Application No: M/71/20/HH
Site Address: 18 Sea Way Elmer Middleton-On-Sea PO22 6JY
Description of works: Construction of first floor dormer to provide enlarged bathroom and wardrobe/storage, construction of detached garage

Thank you for your internet representation made on 21st October 2020 which has been recorded as an objection with the comments as follows:

DRAWING TITLE
**PROPOSED DETACHED GARAGE
FLOOR PLAN AND ELEVATIONS**

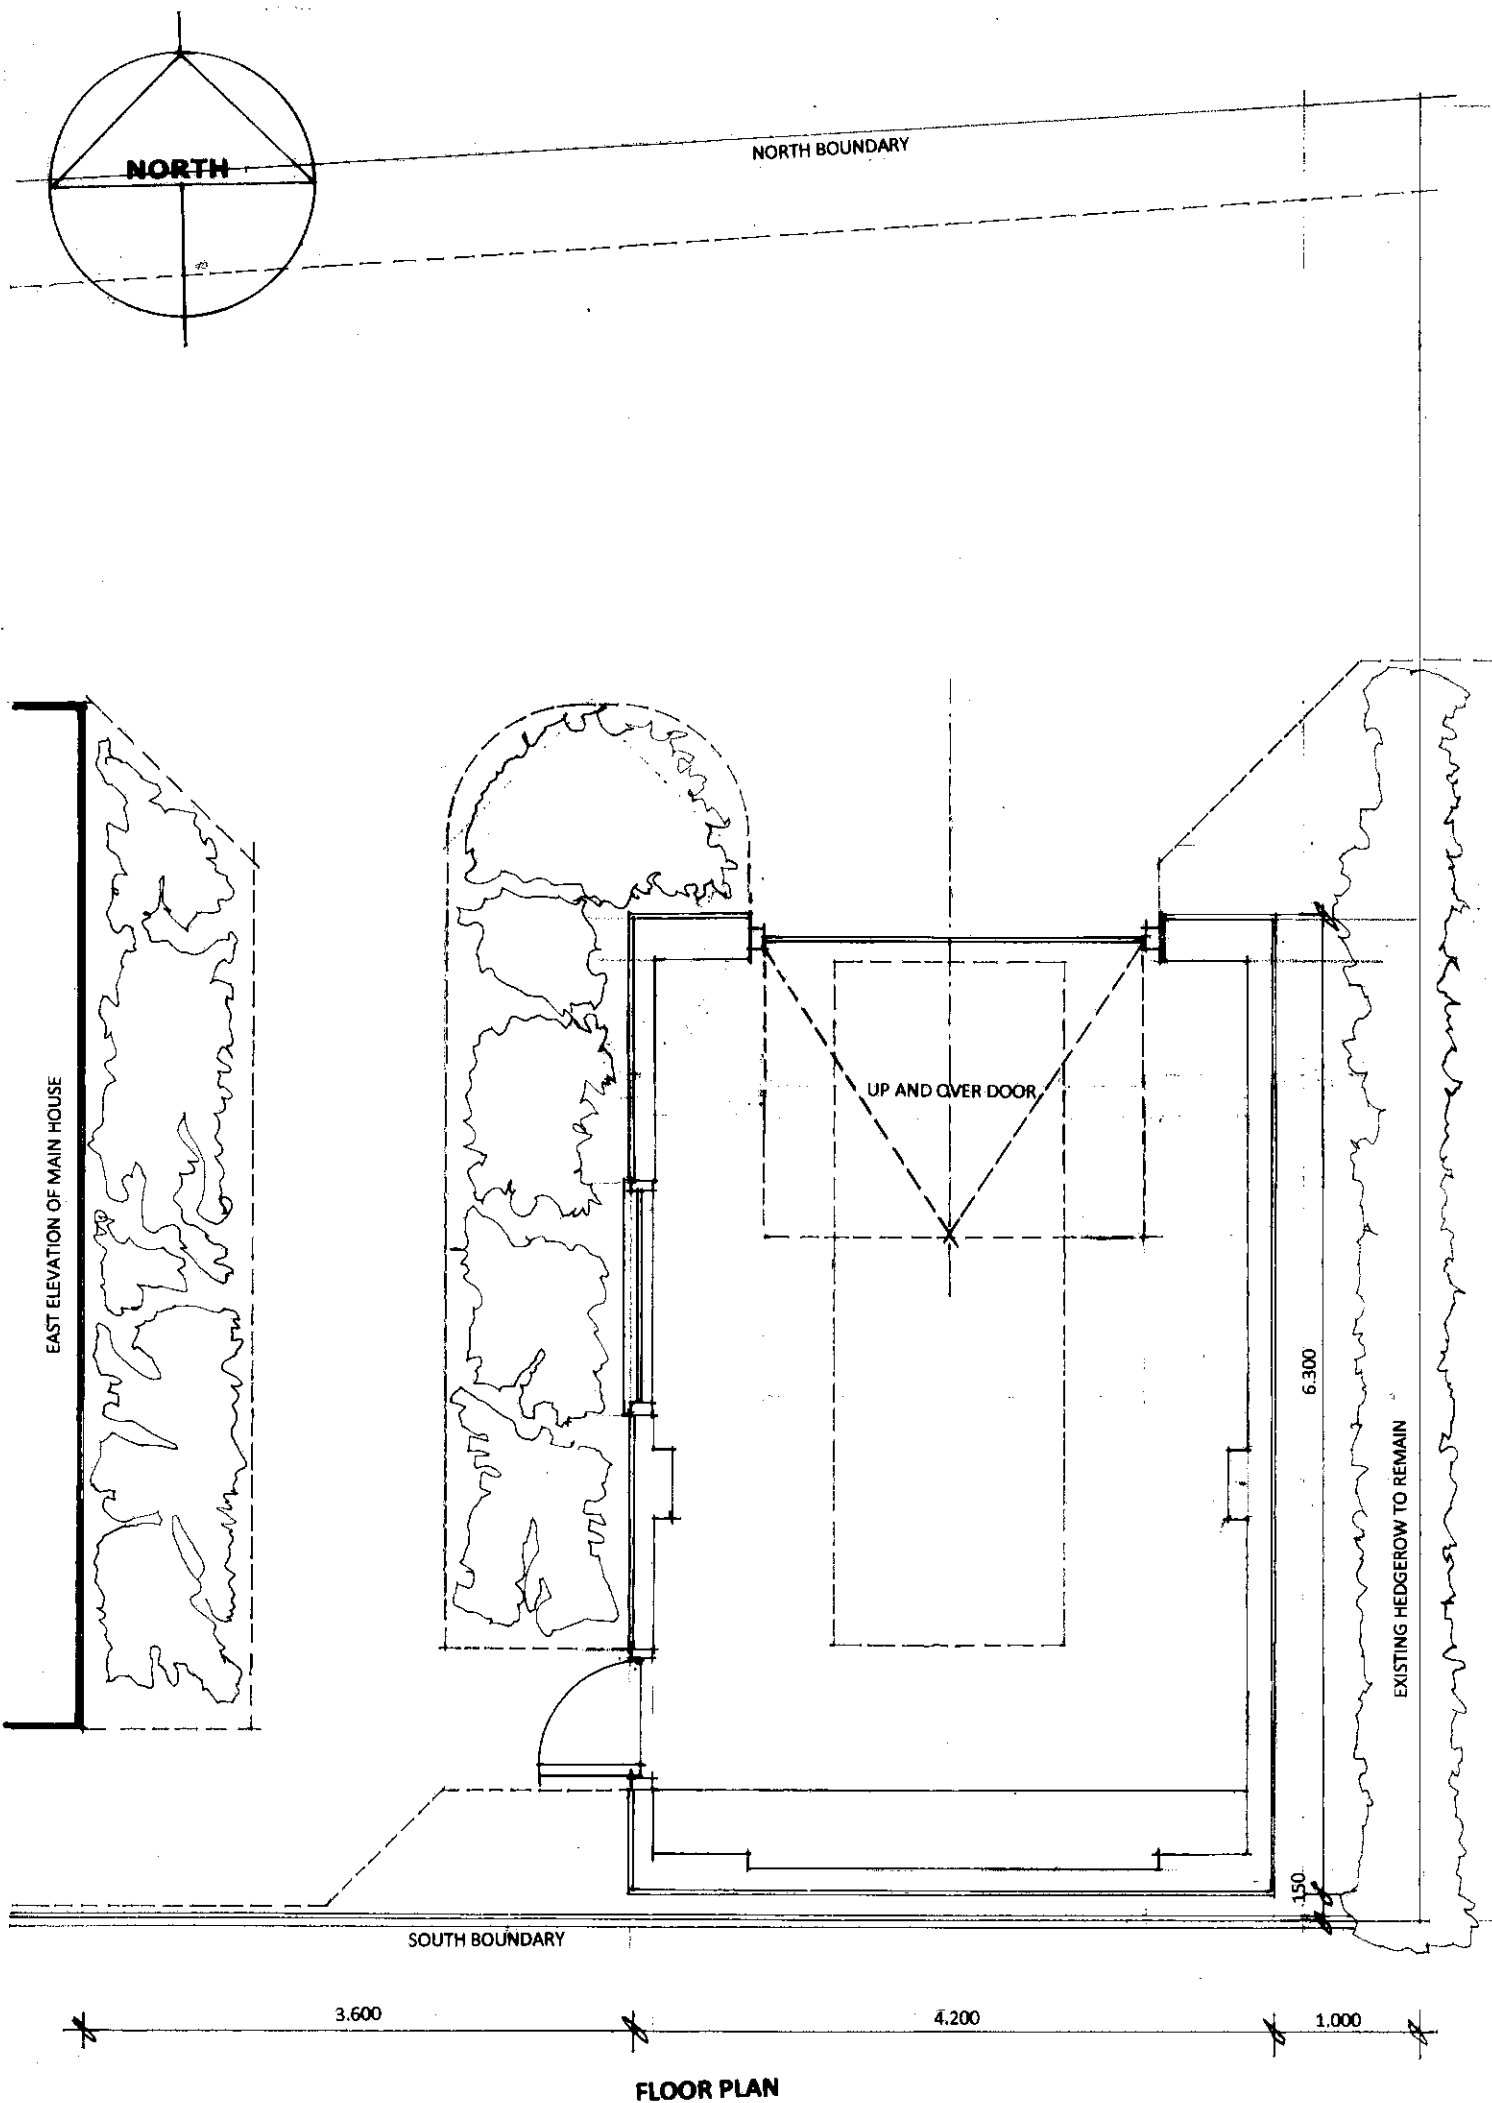
The plans to extend and add a detached garage. for this holiday home would place properties in the Hard and Sea way at risk of further rainwater flooding. The green in front of our houses floods every year and their is limited drainage to the sea that is effected by tides. This development will impact drainage and add to the surface water that floods this area every year. Arun are aware of flooding and have stopped similar developments from adding to the flood risks and this application puts people that live here at risk and the development is not in keeping with any other houses in the area. It should not be passed by Arun planners.
